May 30, 2024

The following are Public Health's comments on the SP-24-00008 Frosty Pines II.

FROSTY PINES II			
SP-24-XXXX			
FROSTY PINES, LLC			
SE 1/4 NW 1/4 AND NE 1/4 SW 1/4 OF SECTION 16, T.21 N., R.14 E., W.M.			
SURVEYED BY: JC	DRAWN BY: SW	CHECKED BY: VW	APPROVED BY: SW
DATE: MARCH 2024	APPROX. JOB NO.: 1565.005	ACAD NAME: 1565005SP	
			SHEET 2 OF 3

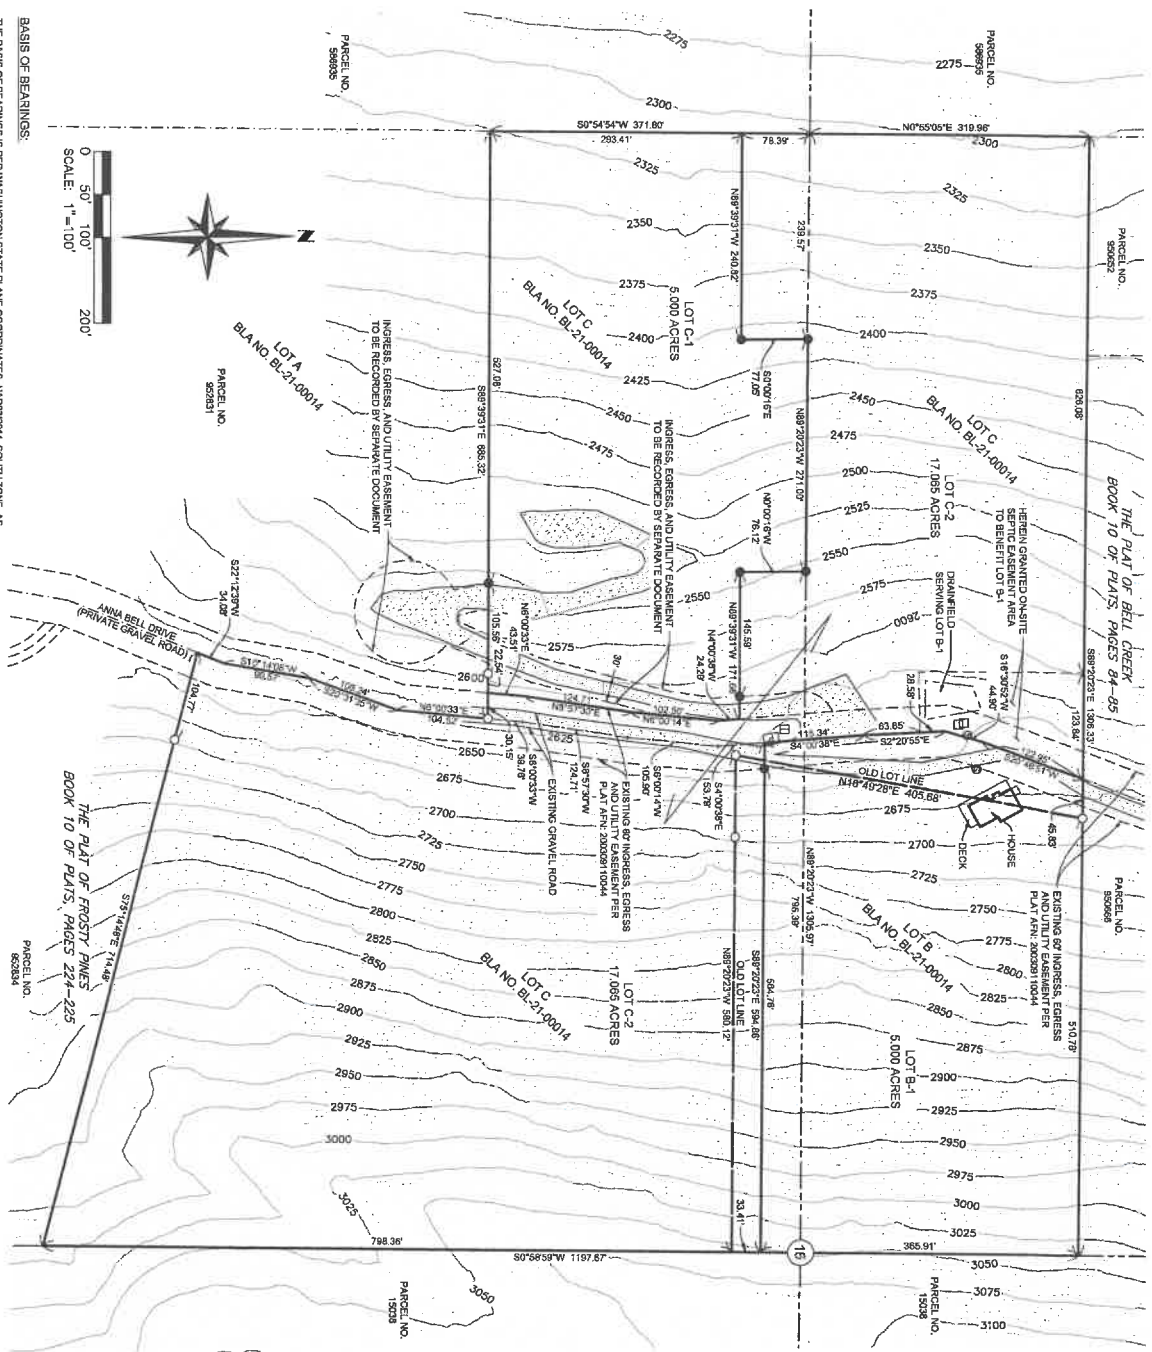
1. At least one soil log per lot not already served by on-site septic must be provided before final plat approval.
2. A signed, notarized and recorded two party shared well users' agreement between the lots to be served by the individual well and well log for the existing well must be submitted to the Health Department for review.
3. Establish a one-hundred-foot protection zone around each existing and proposed well site.
